Case Officer: Hannah Kersley
Reference: BR/5/22/T
Location: 36-37 Servite Close, Bognor Regis, PO21 2DE
Proposal: 1no. sweet chestnut (T1) - Reduce 3 lowest branches away from conservatory by 2m. 1no. *Acer* (T2) - Crown reduction to height 7m and spread 5m
Reasons given: To deter squirrels from accessing conservatory roof and damaging property

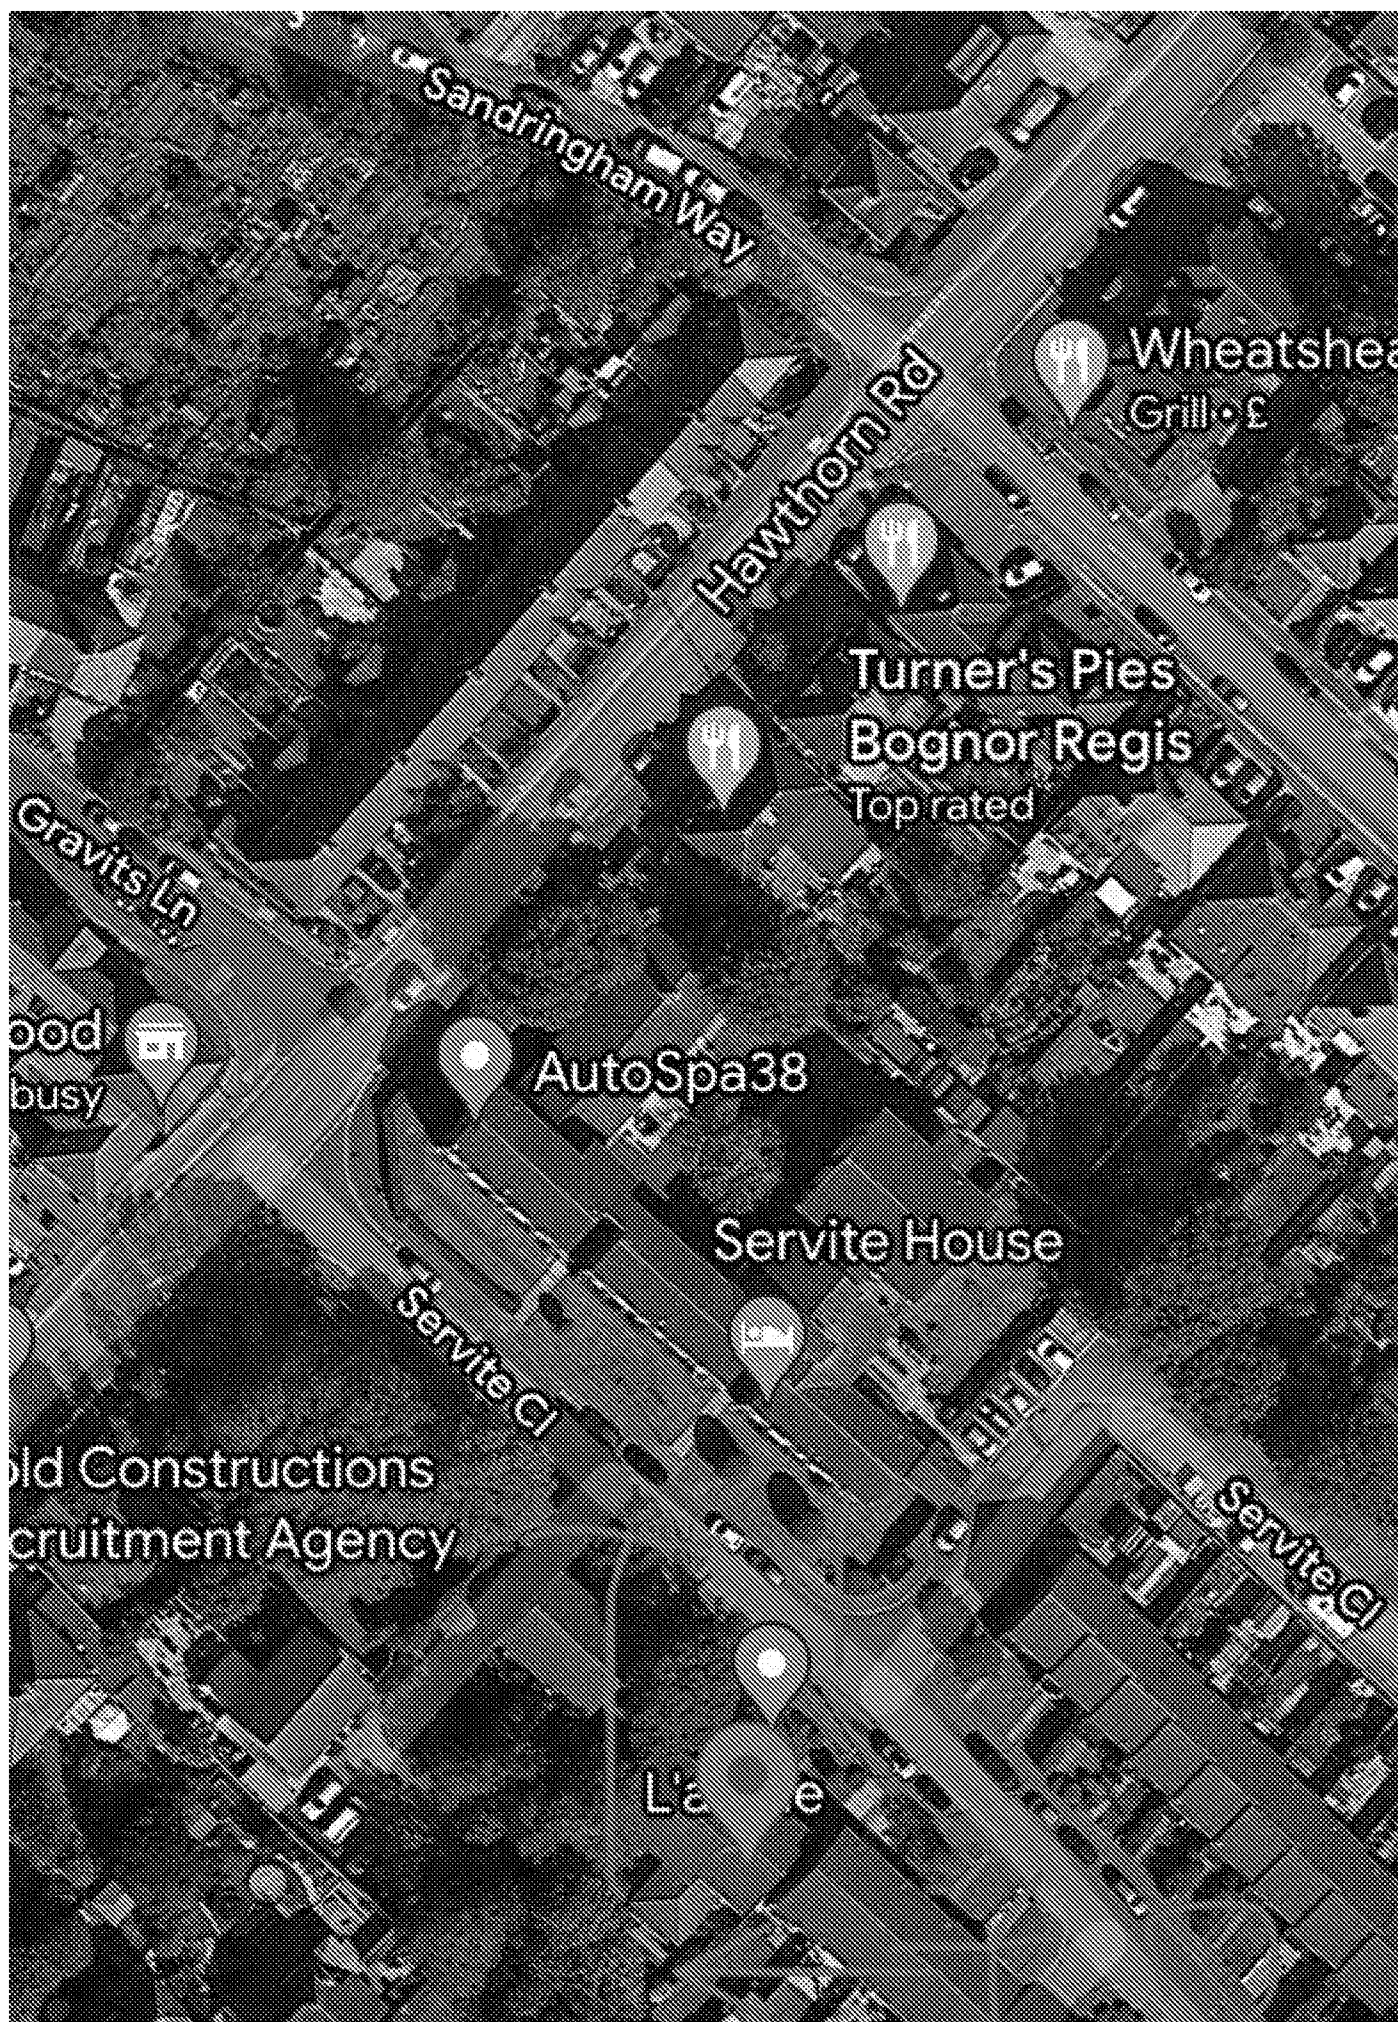
T1 Sweet chestnut / *Castanea sativa* Height: 10-15m Radial spread: 0-5m Age class: Early mature (TPO ref: T40)

- The property is affected by TPO Bognor No.18. Having considered the supporting Schedule and Plan I am satisfied that only T1 is a subject of that Order. T2 *Acer* is not a suitable candidate for a new Order, so we need not consider it further.
- Outwardly and from a distance (residents car park rear of 39/40 Servite Close) this tree appears to be in a fine physiological state and assumed to be so in the absence of any evidence provided to the contrary. It has good form and is visually impressive, dominating much of the property's rear garden.

- The work proposed is justified on arboricultural grounds. This specimen tree is to be carefully pruned to maintain reasonable enjoyment of residential property and with respect for natural tree form.
- There will be no loss of public amenity on completion of the proposed work.

Part a) Where whole branches are to be removed and final cuts made close to the trunk or branch union they are to be made as shown in Figure 2 of BS3998:2010

Part b) Where branches are to be shortened back the final cuts are to be made at the correct angle shown in BS3998:2010 and adjacent to a live bud or lateral.

Part c) Pruning will be applied only to small diameter branches with all final cuts being no greater than 50mm diameter and to achieve a maximum of 2metres clearance from building/conservatory.
